Appeal Decision

Appeal Ref: APP/R4408/W/23/3323511

4 Springfield Place, Barnsley S70 6HJ

- The appeal is made under section 78 of the Town and Country Planning Act 1990 against a refusal to grant planning permission.
 - The appeal is made by Mr Ben Shufflebottom against the decision of Barnsley Metropolitan Borough Council.
 - The application Ref 2022/0616, dated 10 June 2022, was refused by notice dated 5 December 2022.
 - The development proposed is erection of 3 storey side/rear extension to form HMO 6 person and associated external works.
-

GROUND FLOOR

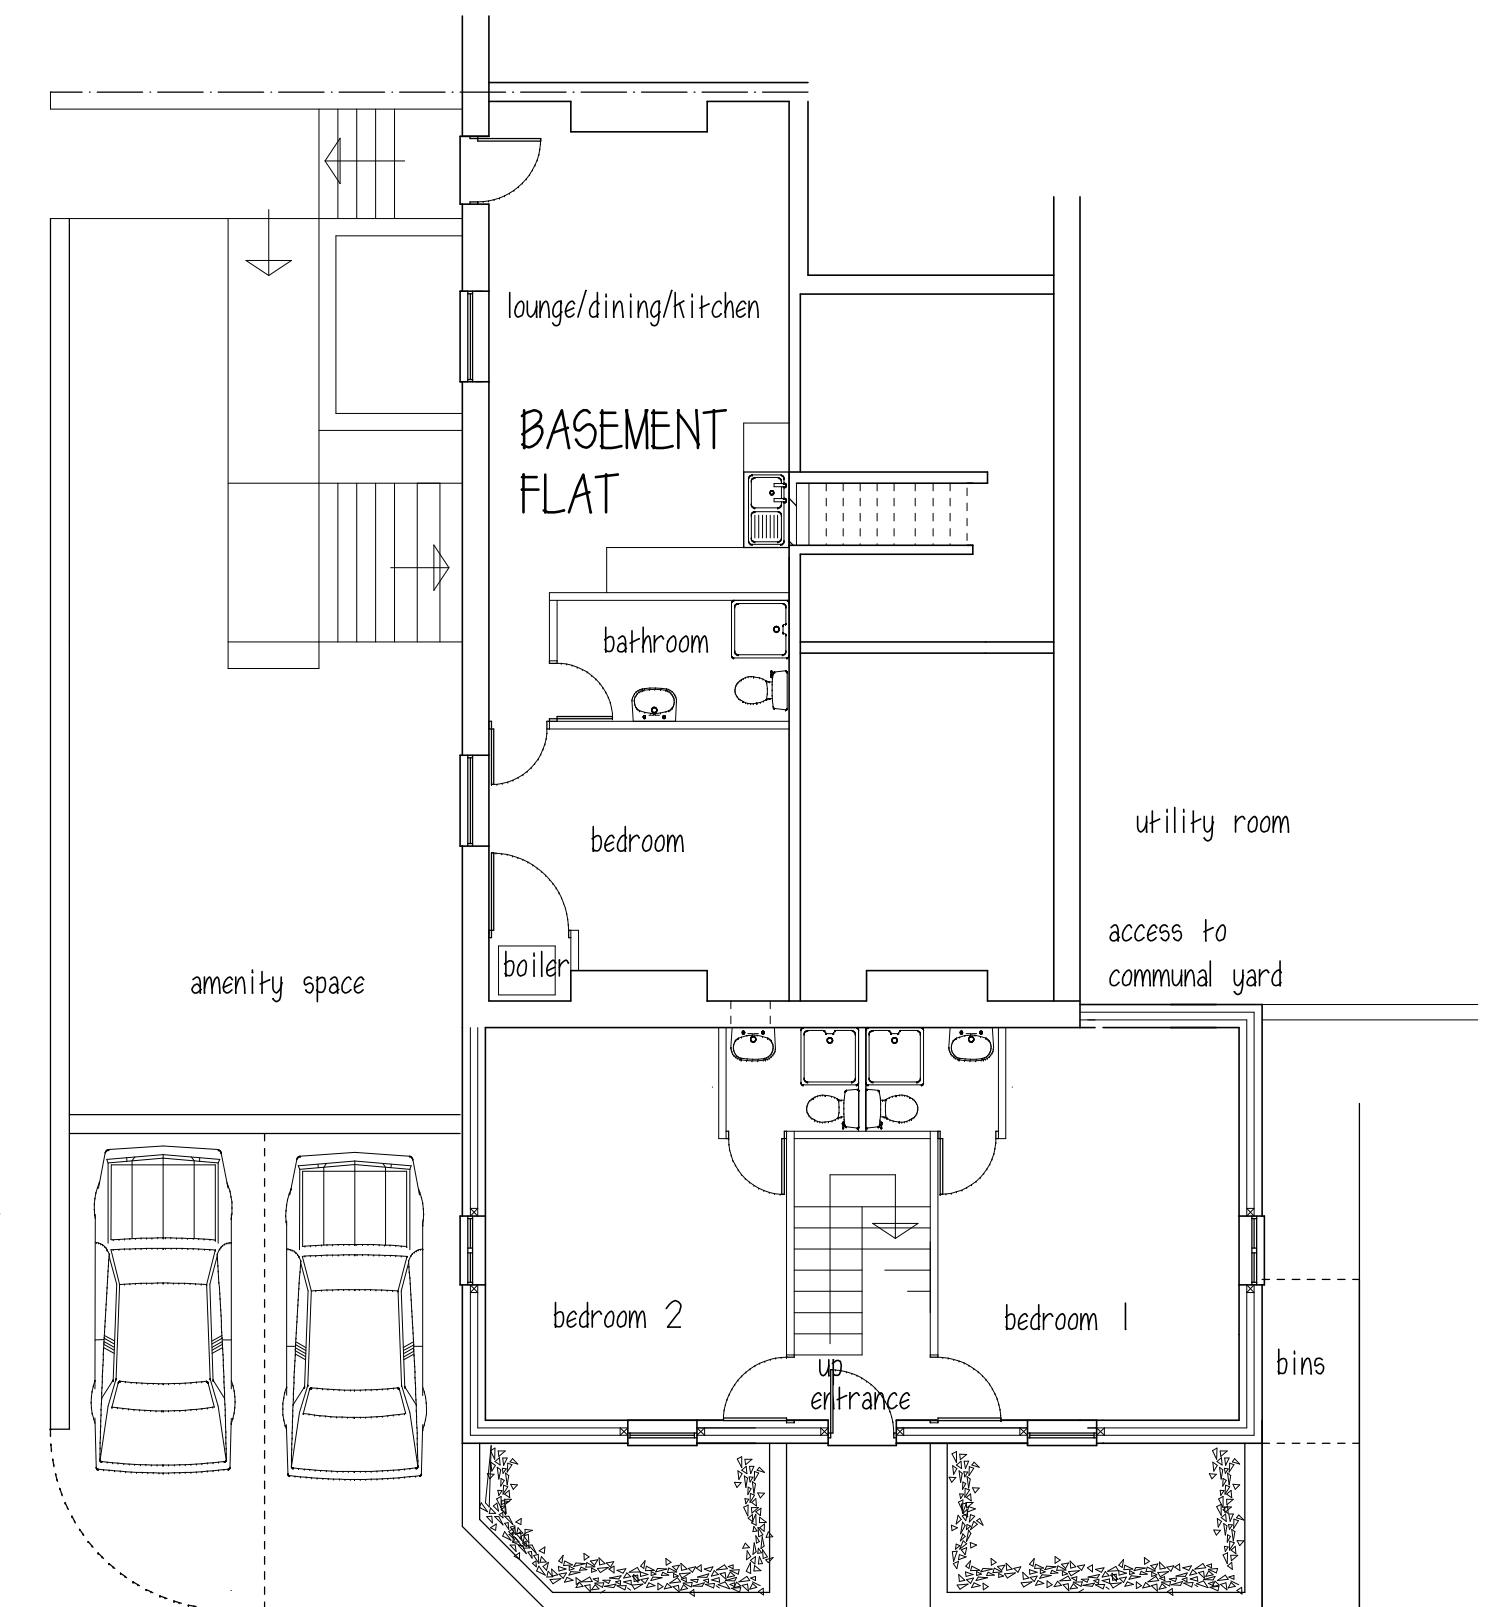
7. The proposal includes one area of shared internal amenity space to serve as a kitchen/dining room with a small area of storage space and no additional area for a shared lounge. The proposed kitchen/dining room would not be of a sufficient size to accommodate up to six people preparing and eating food and relaxing at the same time.

9. In addition, the proposal does not provide private amenity space and only limited shared outdoor space. Whilst there are areas of green space within walking distance of the appeal site, these do not provide private space for the occupiers for activities such as drying washing and immediate access to outdoor areas. This lack of outdoor space would therefore harm living conditions of future occupiers. Whilst this is similar to the previous approval for 2 flats in terms of amenity space, I have to have regard to the application before me.
